# ENG-PUDSP21005-R4-GEC.pdf Markup Summary

**Subject:** SW - Textbox with Arrow  
**Page Index:** 2  
**Date:** 9/7/2022 12:33:04 PM  
**Author:** Glenn Reese - EPC Stormwater  
**Color:** ■  
**Layer:**  
**Space:**  
**Page Label:** [1] SHT 2 EC INITIAL

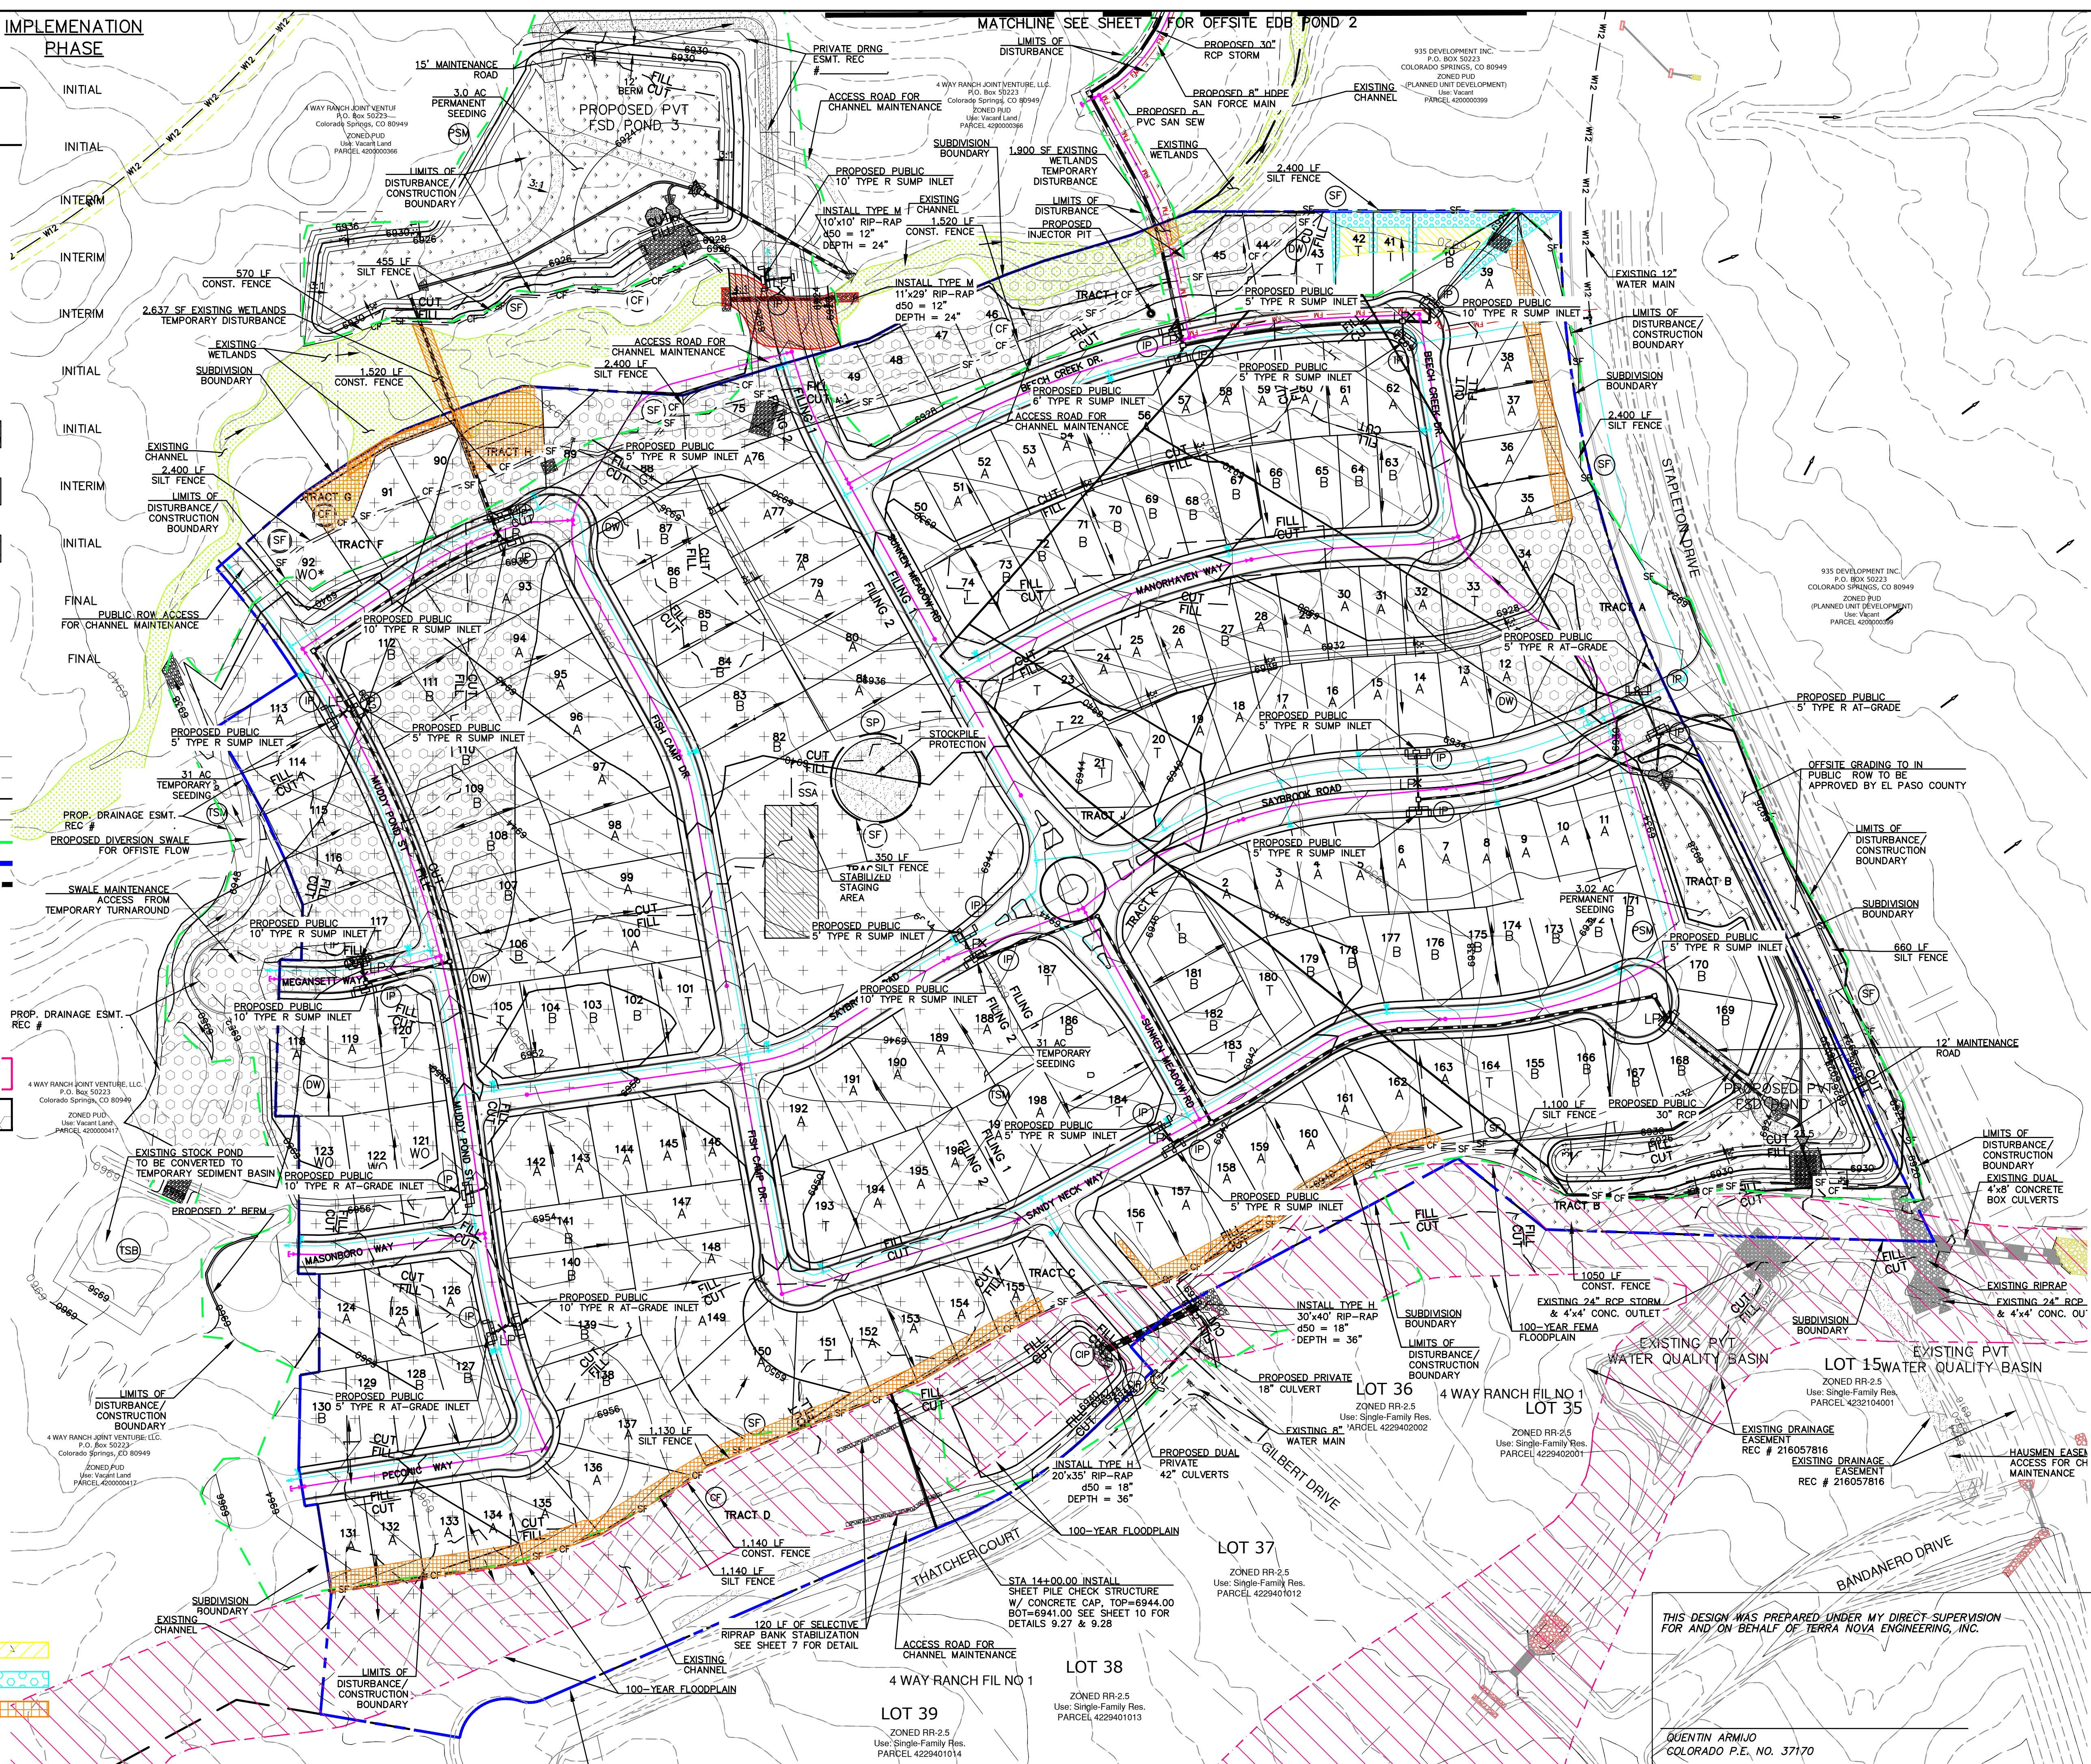
Unresolved-Curb and gutter shouldn't be out this far

revise per comments on pdf pg 312 of Drainage Report.

Label floodplain elevations

Label floodplain elevations
